**Consultation Response from KC,
Highways Development Management**

2024/92302 Huddersfield Bus Station, Upperhead Row, Huddersfield, HD1 2JN

Date Responded: 12/09/2024

Responding Ref: K5-7NW/45

**6.2 The Canopy Ground Level Layout**

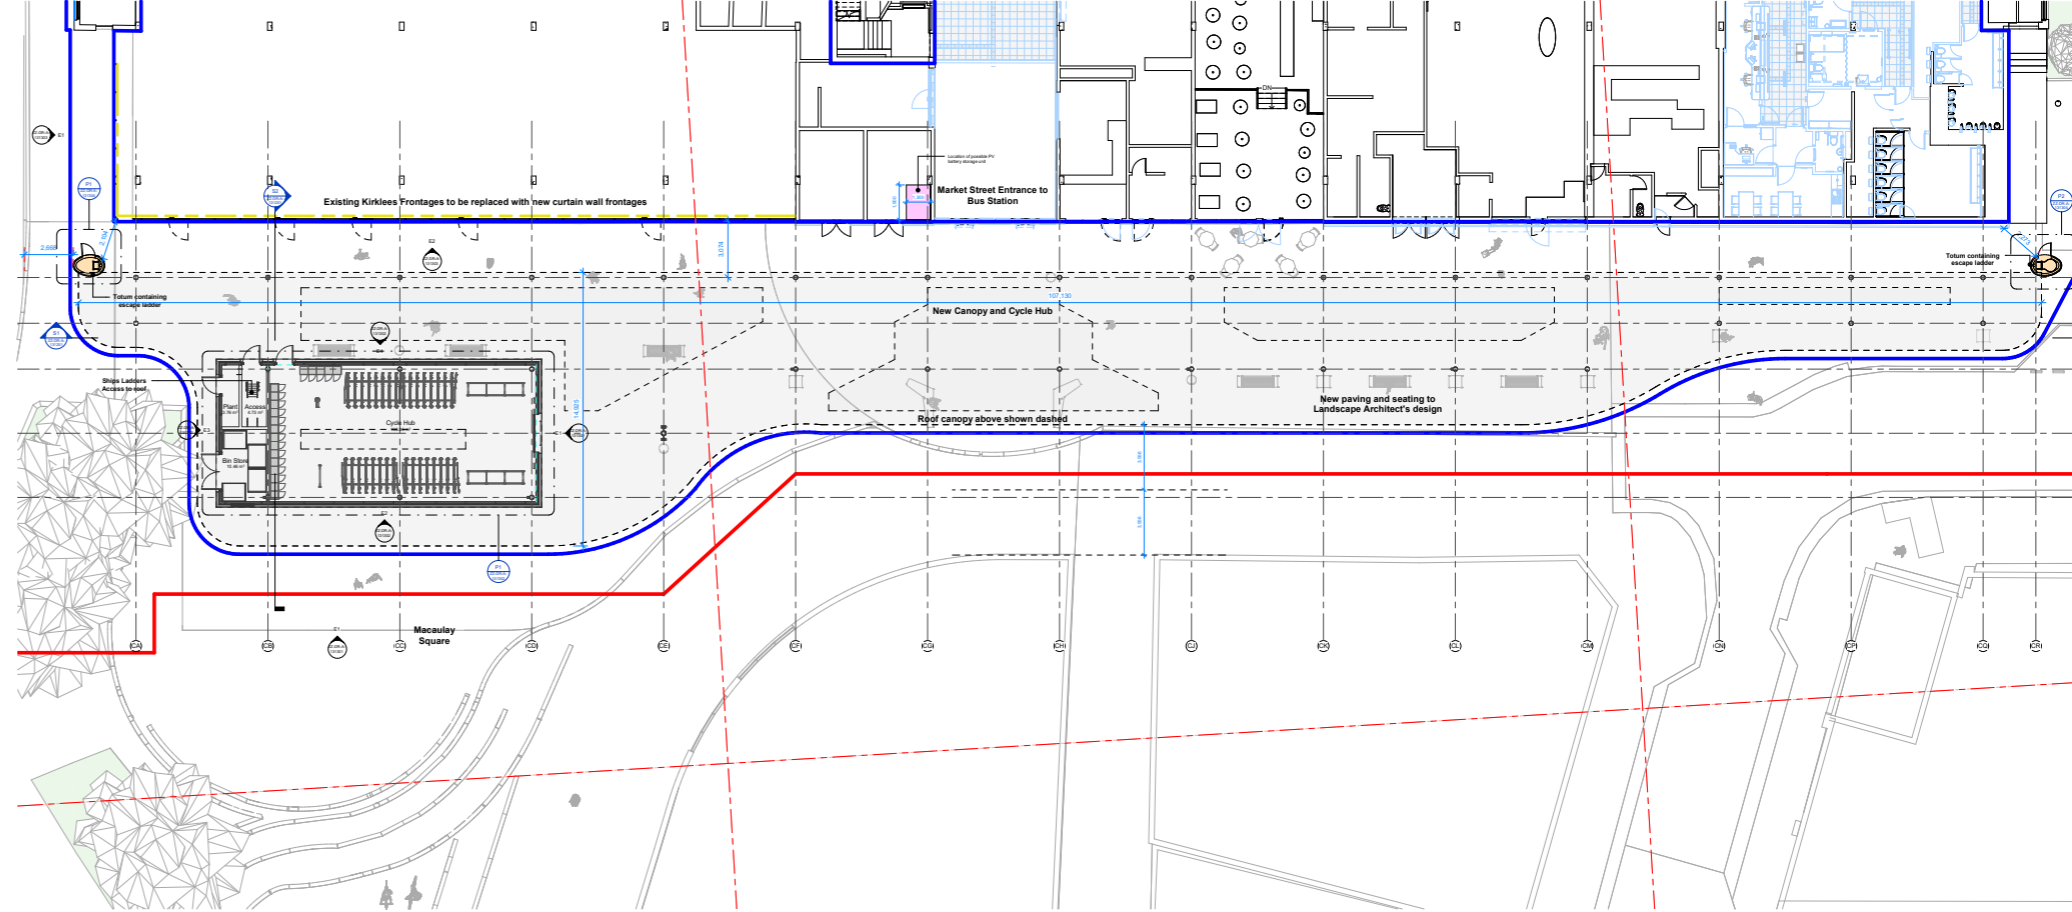
The cycle hub is viewed as a positive addition to the development as it will promote sustainable and active travel within Huddersfield, however as it is to be built within the adopted highway there are concerns as to whether a stopping up order will be required, and we would recommend that the applicant consults with the Kirklees Highway Registry in relation to this to obtain advice regarding what would be the best way forward to enable delivery of the scheme.

Details of the cycle hub were provided on drawing No 200001 Rev P03, this contains 82 cycle spaces, 57 lockers and a cycle maintenance/repair area and this is acceptable. The cycle hub building also contains a plant room, access to the canopy roof and a bin storage area. No details for the collection point for these bins were included within the application and this information should be provided, including details of the collection point or routes to a suitable collection point/external bin store. Waste storage and collection needs to accord with guidance from the Kirklees Waste Strategy team in relation to types and numbers of bins and suitable collection points. I'm unsure if the Waste Strategy team are aware of the bin storage within the cycle hub building as their consultation comments don't specifically address this. The waste storage and collection details can be conditioned if required.

Proposed Canopy Roof Plan

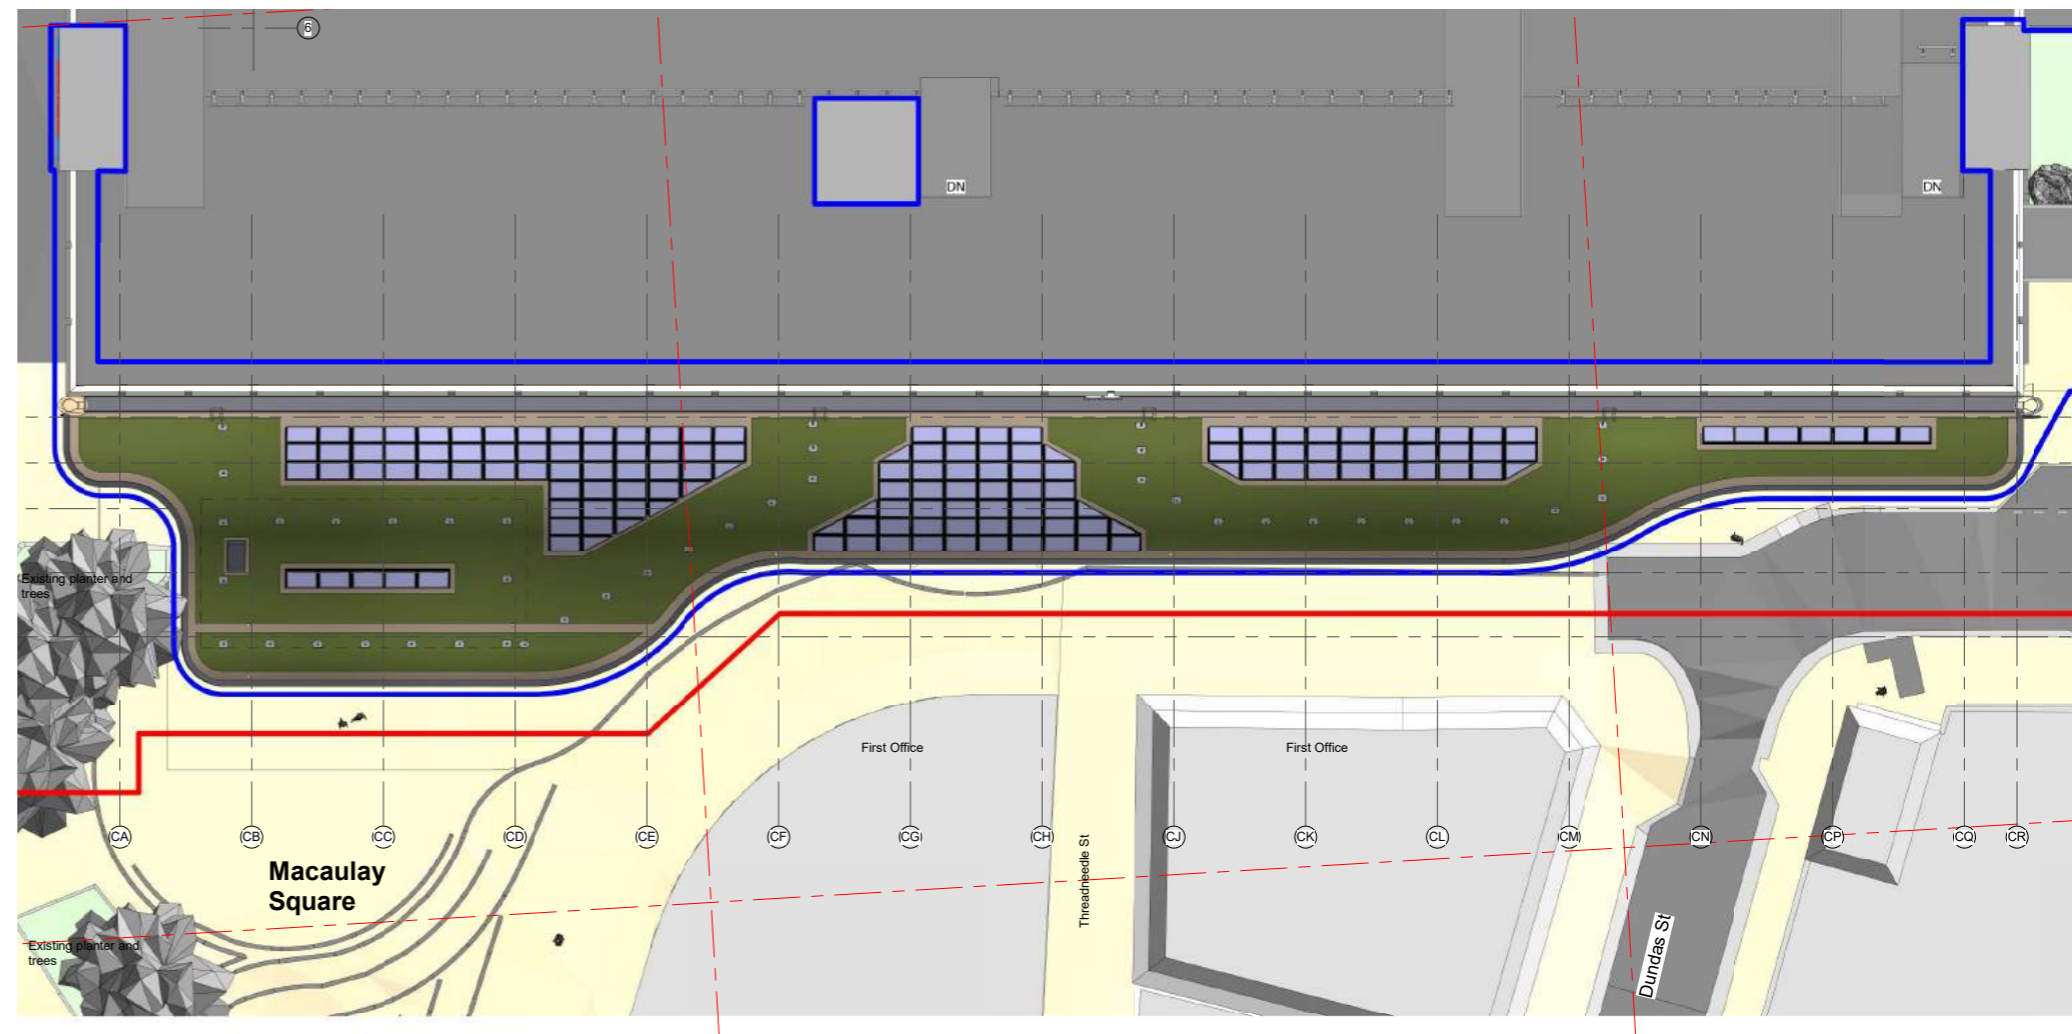
The canopy will overfly the adopted highway, and this will require the correct licence, either a 177

licence or 178 licence, and we would request that the applicant obtains guidance for this from the Kirklees Licencing section or Highway Registry. A footnote is added in relation to this.
